Historic England

Our ref: P00443887

1 October 2015

**Arrangements for Handling Heritage Applications Direction 2015 &  
T&CP (Development Management Procedure) (England) Order 2015  
PROPOSED HIMLEY VILLAGE NORTH WEST BICESTER MIDDLETON STONEY  
ROAD BICESTER OXFORDSHIRE  
Application No 14/02121/OUT**

Drawing Title
Landscape - Parameter Plan 3

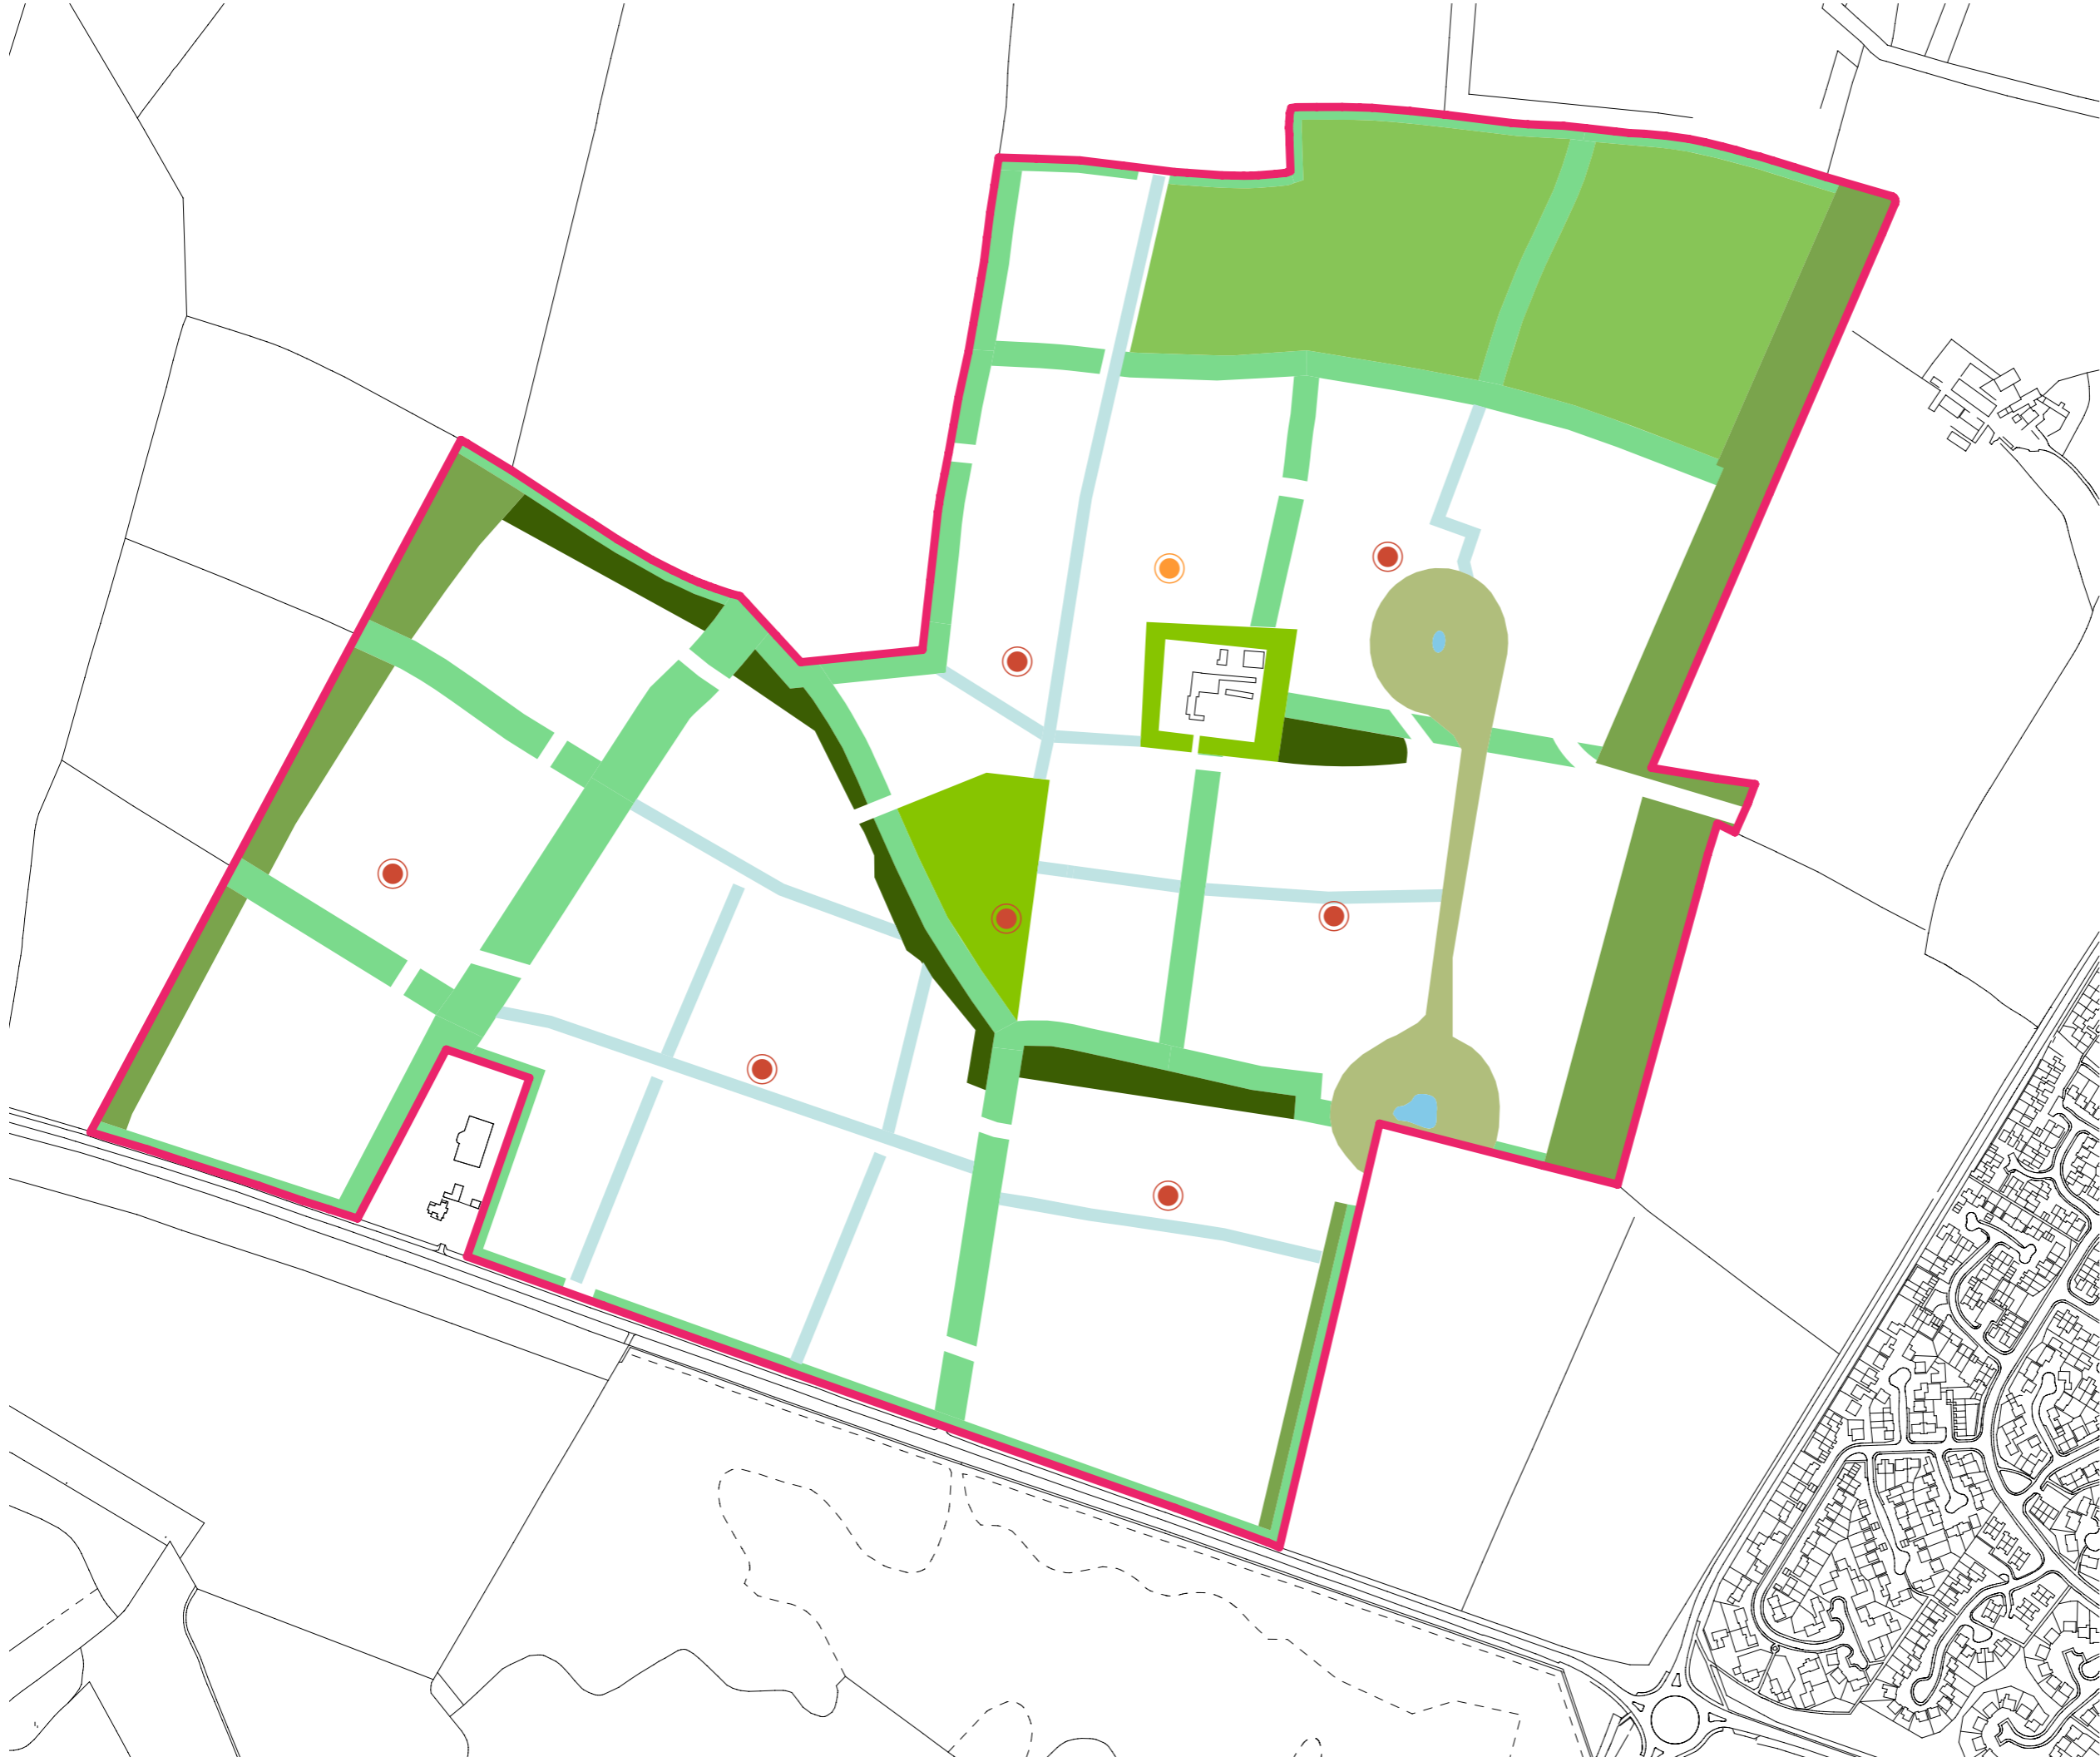
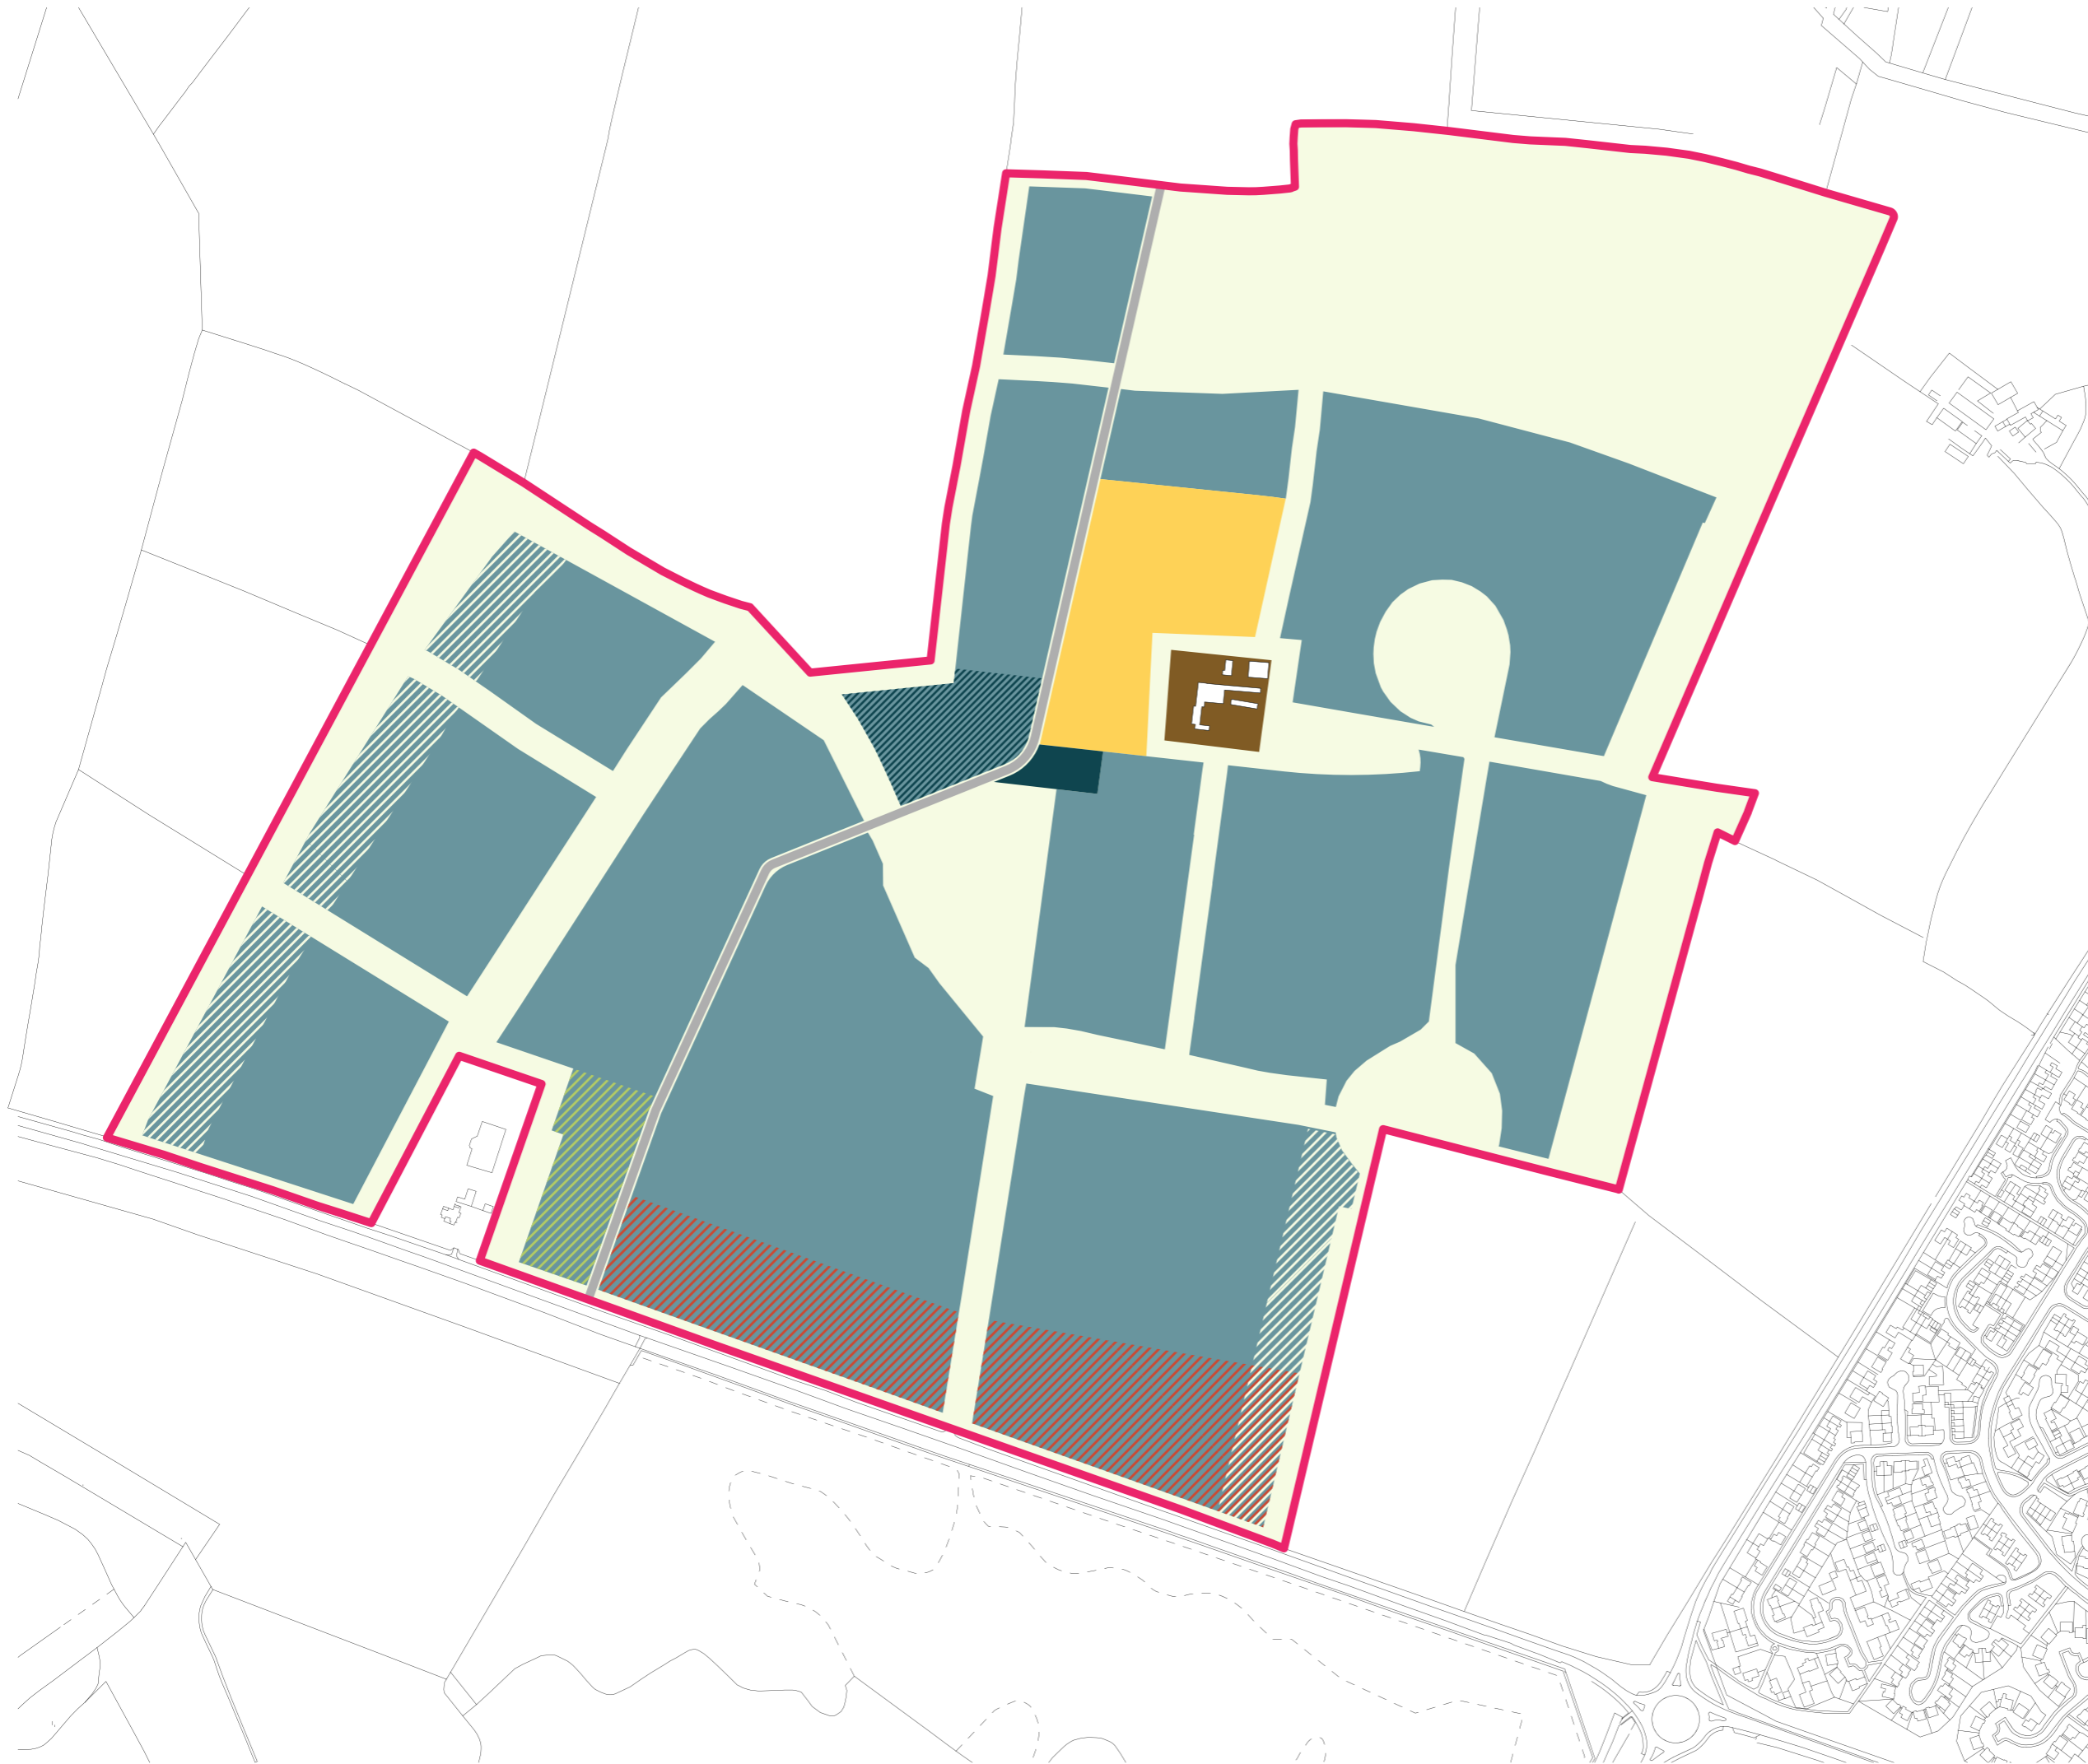
Historic England welcomes the decision to provide additional green space around the Grade II listed barns at Himley Farm (shown in amended Parameter Plan 3) as this would help reinforce an understanding of the buildings historic relationship to the surrounding agricultural field system.

However, this amendment would not and cannot hope to completely offset the residual harm that will inevitably arise from the loss of the wider agricultural landscape setting currently afforded to the buildings at Himley Farm. That said the impact of the new development could be mitigated (as highlighted by Paragraph 129 of the NPPF) through the detailed design of landscaping close to the listed barns. This should reference the character of the existing landscape (as an agricultural holding) as far as possible. We would also suggest the scale of new development close to the barns should be kept to the minimum necessary to avoid the possibility of large buildings overwhelming the more diminutive scale of the barns. If your Council is minded to approve this application because you consider the public benefits of providing new housing outweighs the harm entailed to the significance of the Grade II barn (as required by Paragraph 134), we suggest our comments above are taken into account at reserved matters.
